# Consultee Comments for Planning Application 16874/23

Application Number: 16874/23

Address: St Andrews Place Hill Lane Blackrod Bolton BL6 5JP

Proposal: CONVERSION OF EXISTING COMMUNITY HALL INTO 4NO. COMMERCIAL UNITS TOGETHER WITH EXTENSION TO UNIT ONE AND SOLAR PANELS AT FRONT AND REAR

Proposed Ground Floor Plan

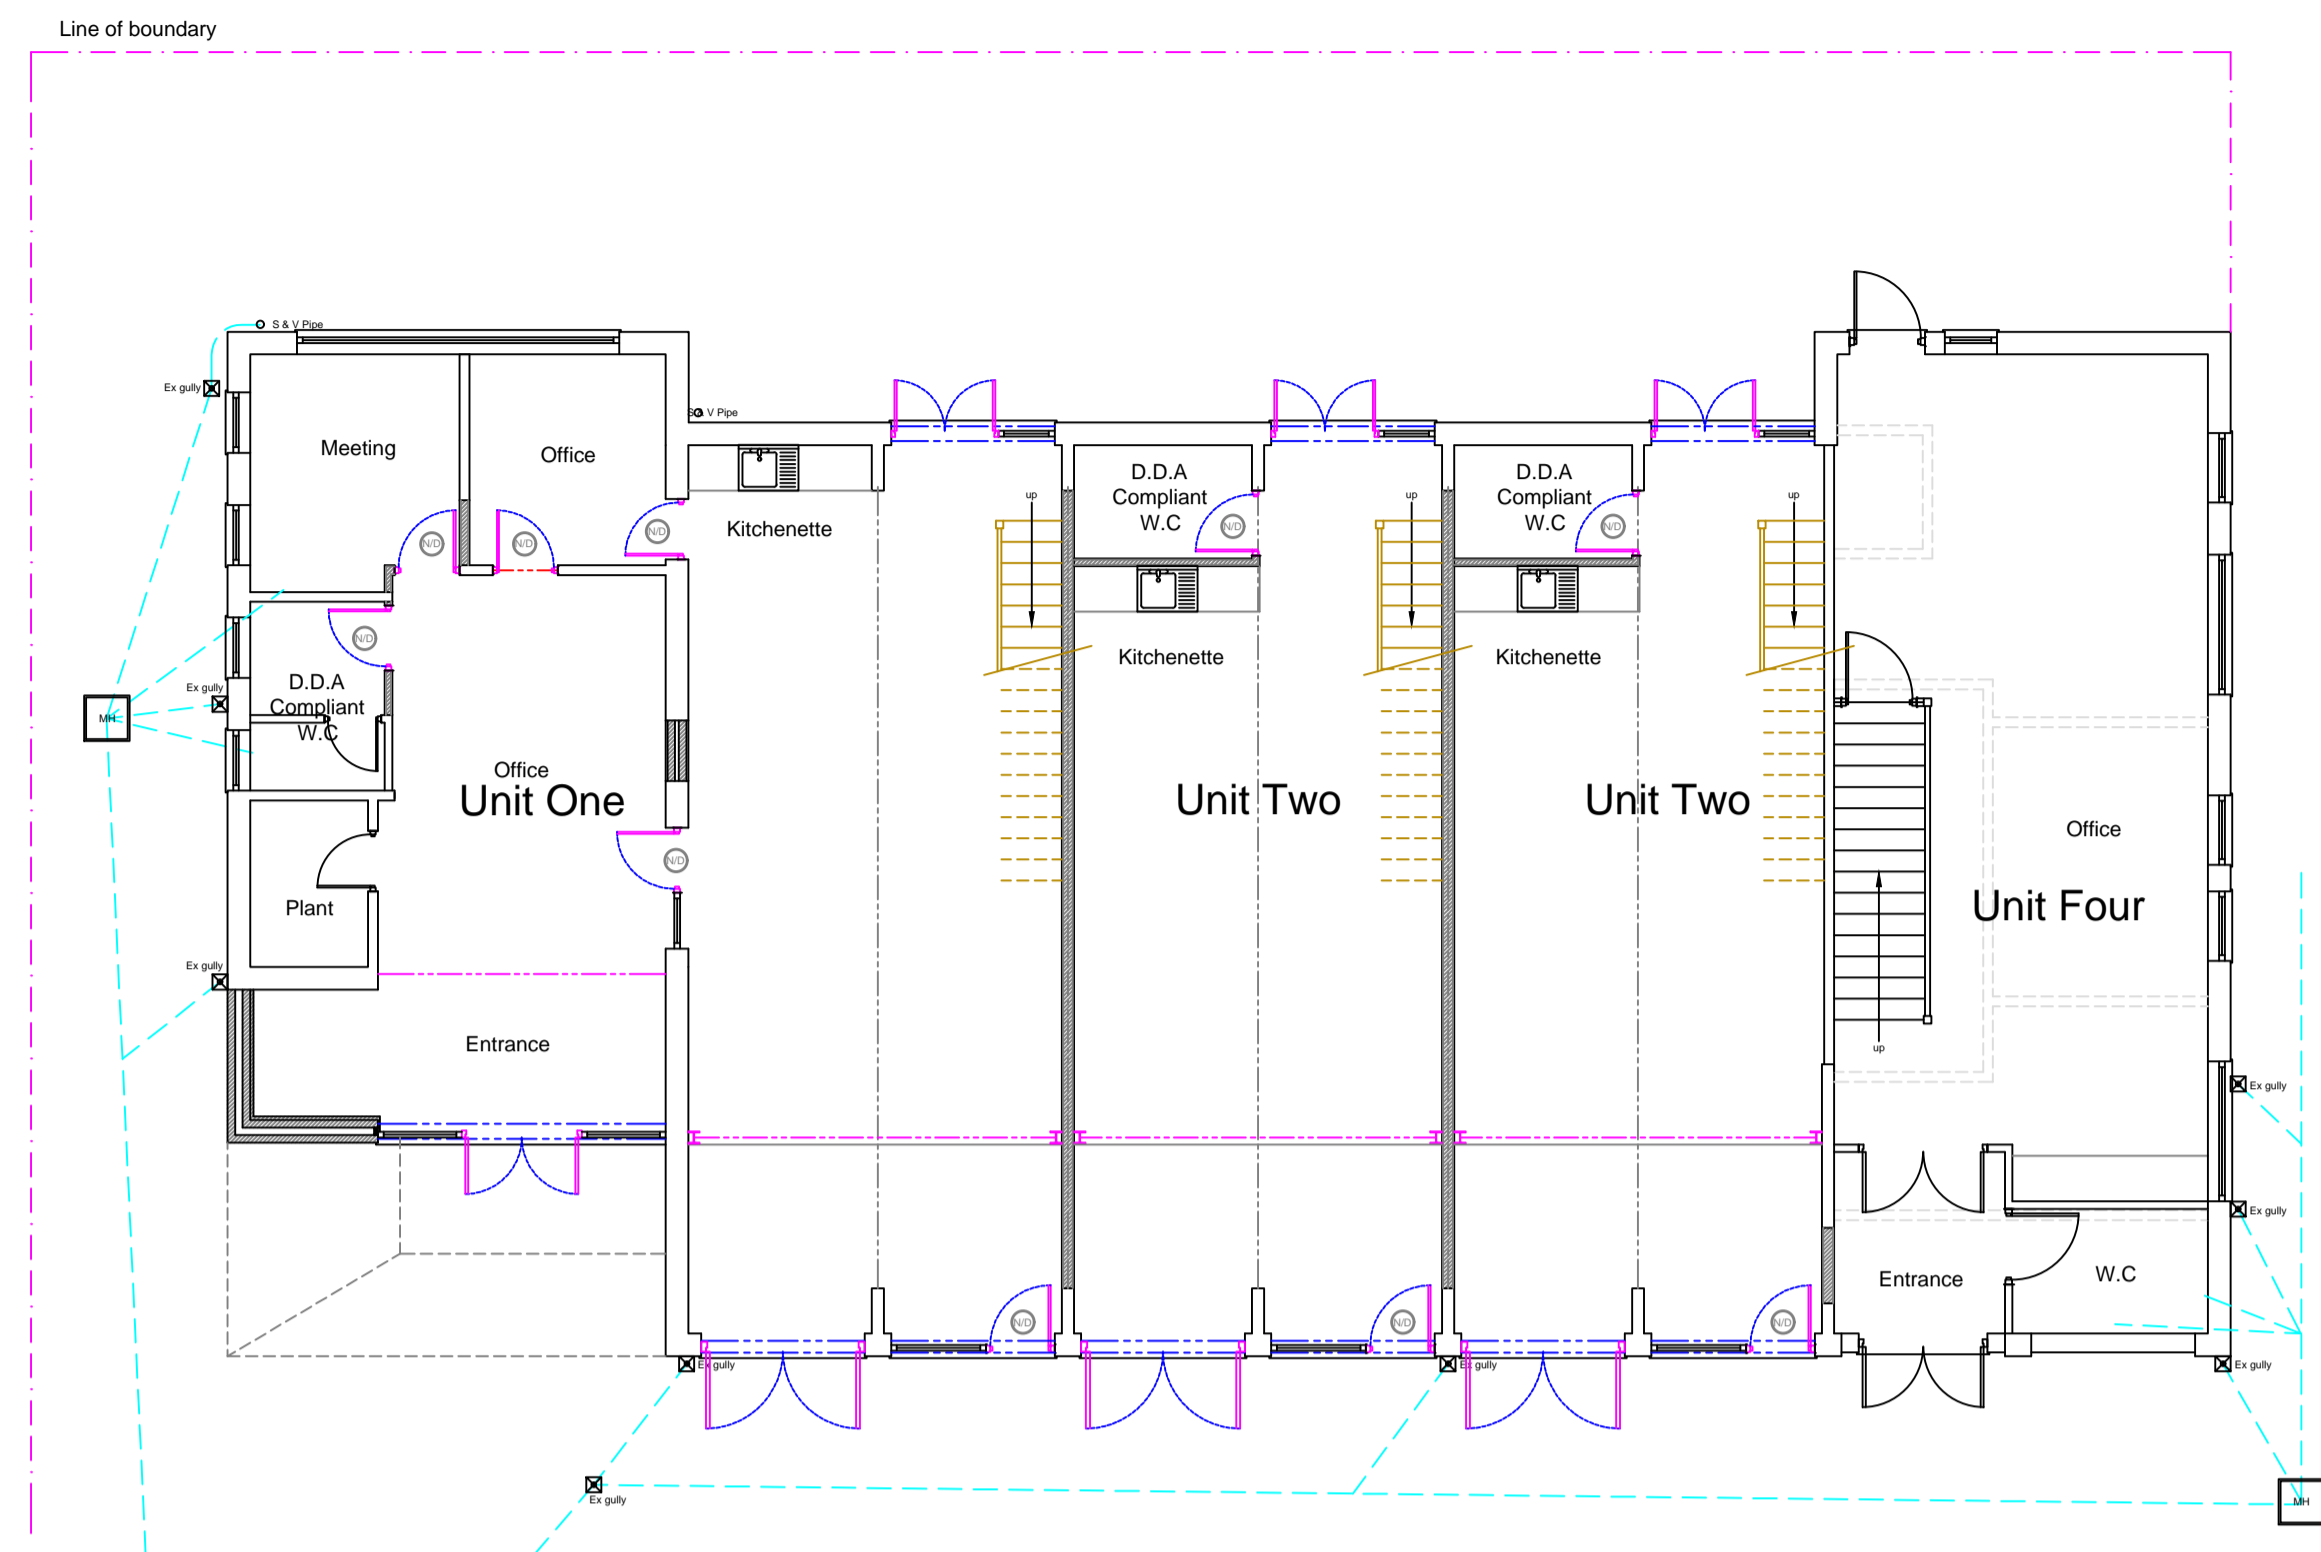
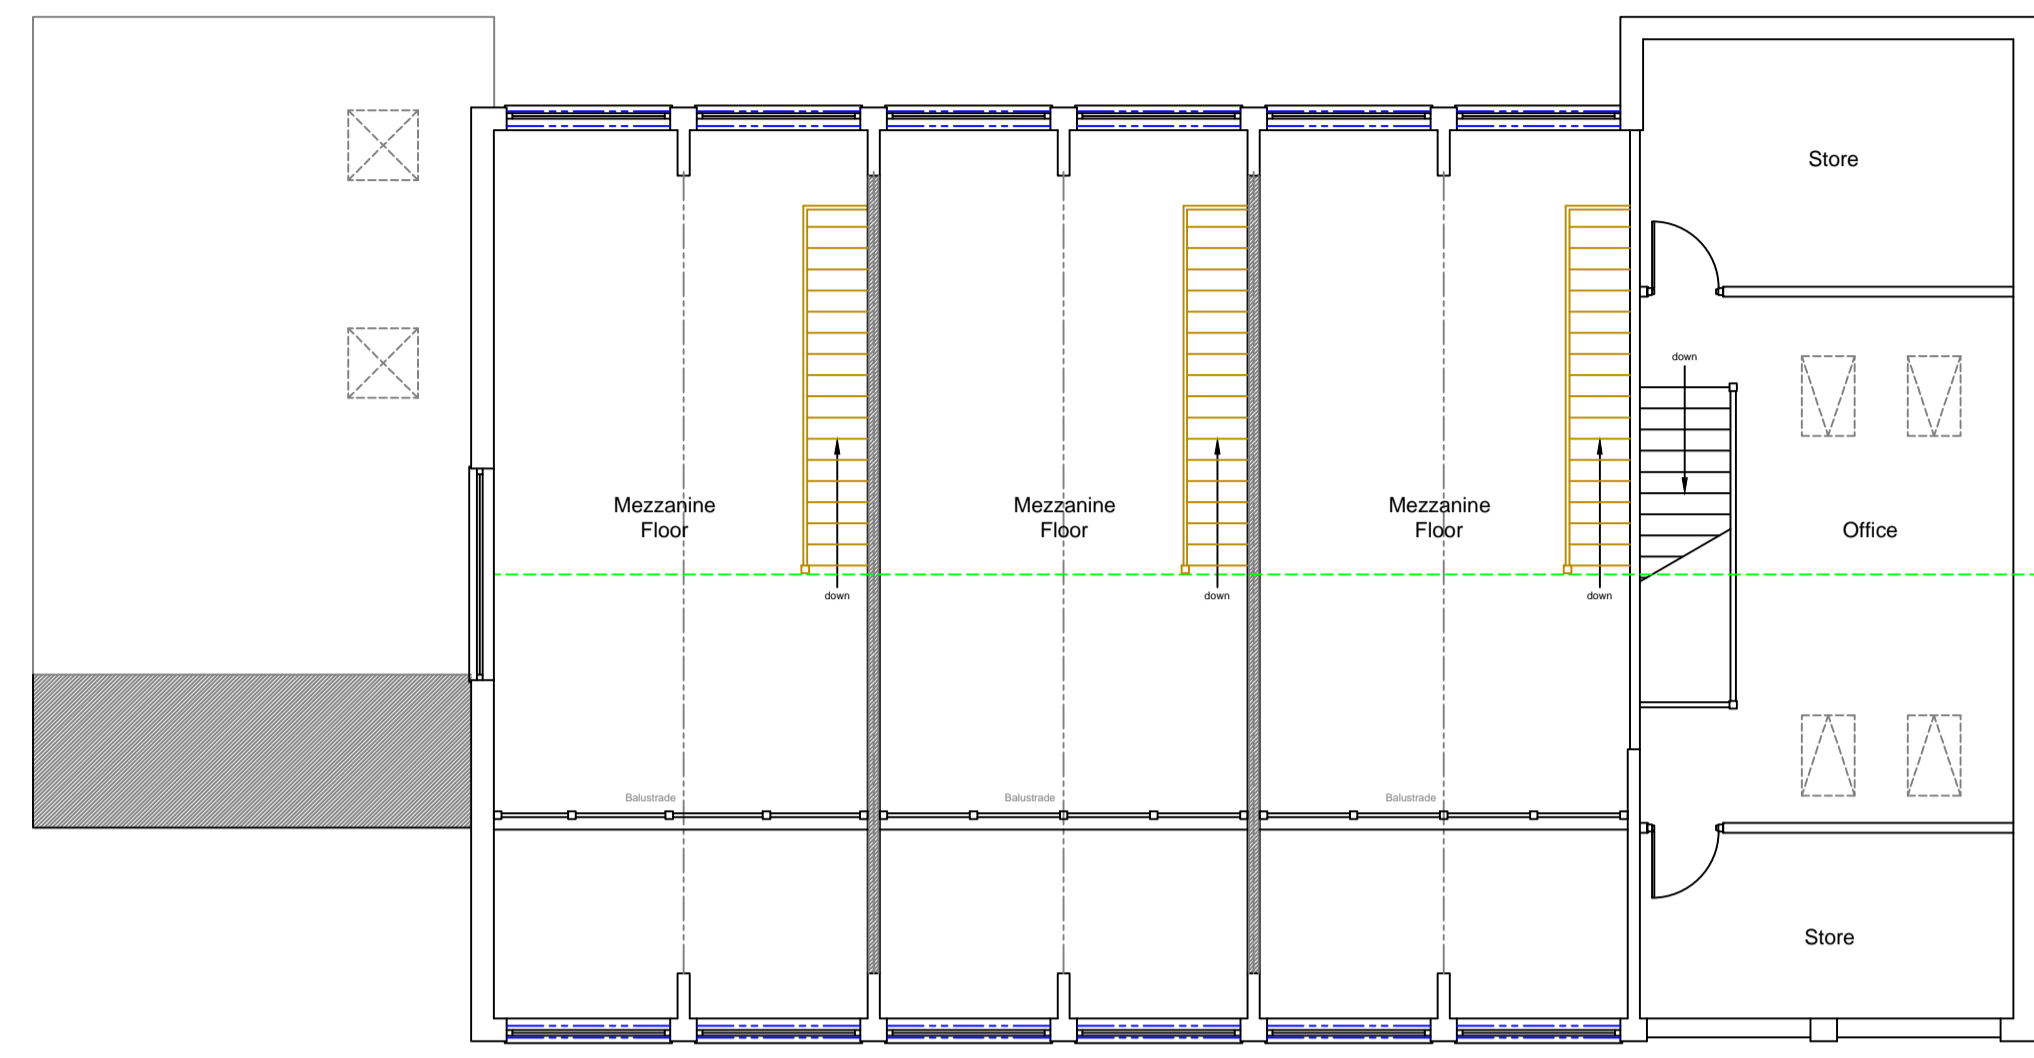
The proposed change of use has the potential to generate minimal additional traffic in comparison to that associated with the extant community use of the premises. This should be accommodated with little additional detriment/severity to road safety, amenity, and the operational capacity of the surrounding highways at that location. The site plan indicates that the commercial uses will benefit from 10 off-road parking spaces. Owing to the residential nature of the surrounding areas and the observed issues with on-street parking at that location, the Councils parking standards should be met in full for the use-classes proposed. The commercial uses proposed within the premises will require an element of accessibility for service vehicle movement. Tracking analysis using industry standard software needs to be submitted for the maximum size of HGV service vehicle that would visit the site to demonstrate accessibility through the existing highway access point from Hill Lane and the ability to manoeuvre within the site and to enter/leave in forward gear with the proposed parking provision in place.

HS05-Compliance with Councils parking standards in line with the level of commercial use proposed.

HS07-Tracking for the maximum size of service vehicle to visit the site to support the level of commercial use proposed to demonstrate the ability to enter/leave the site in forward gear.
